From: [Mau, Russell E \(DOH\)](#)
To: [Chace Pedersen](#)
Cc: [Holly Erdman](#); [Smits, Brenda M \(DOH\)](#)
Subject: RE: LP-24-00002 Nelson View - Notice of Application
Date: Tuesday, April 9, 2024 4:50:12 PM

Subject: LP-24-00002 Nelson View - Notice of Application

**NELSON VIEW PLAT**  
A PORTION OF THE SOUTHEAST 1/4 OF SECTION 20,  
TOWNSHIP 20 NORTH, RANGE 14 EAST, W.M.,  
KITITITAS COUNTY, WASHINGTON

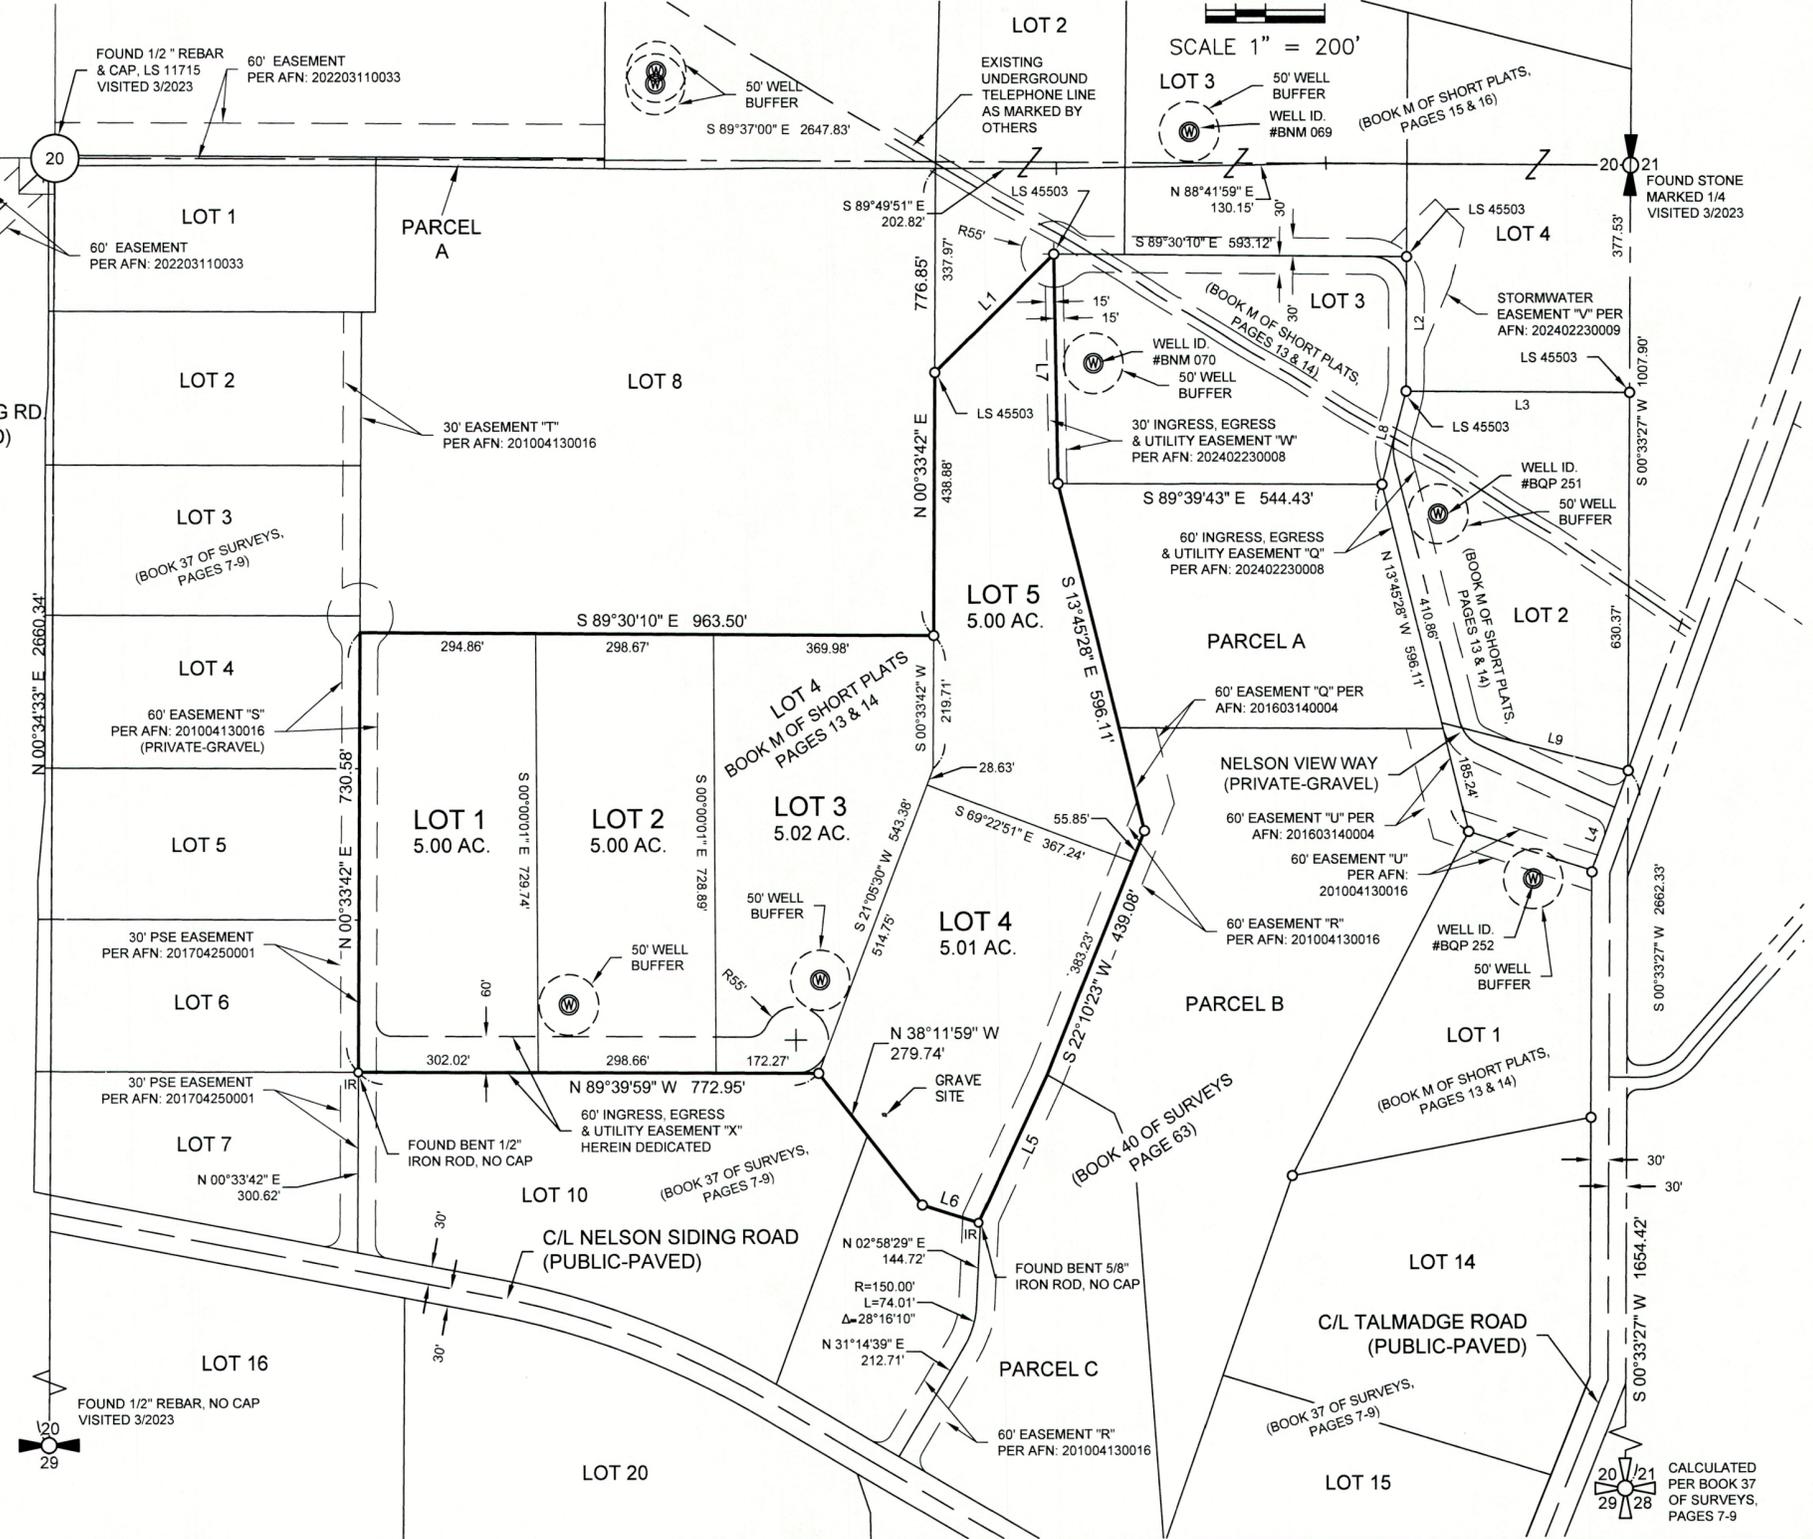
The previous application was for 11 lots, this one shows 5 or 6. Are the 5 or 6 part of the 11?

And, the applicant, for this application, proposed individual or shared wells – it is a “project” and they need to consult Ecology regarding how to implement water extraction for a project.

This plat is associated with SE-23-00009 Nelson View. An MDNS was issued on 6-29-2023.
SEPA #202303157
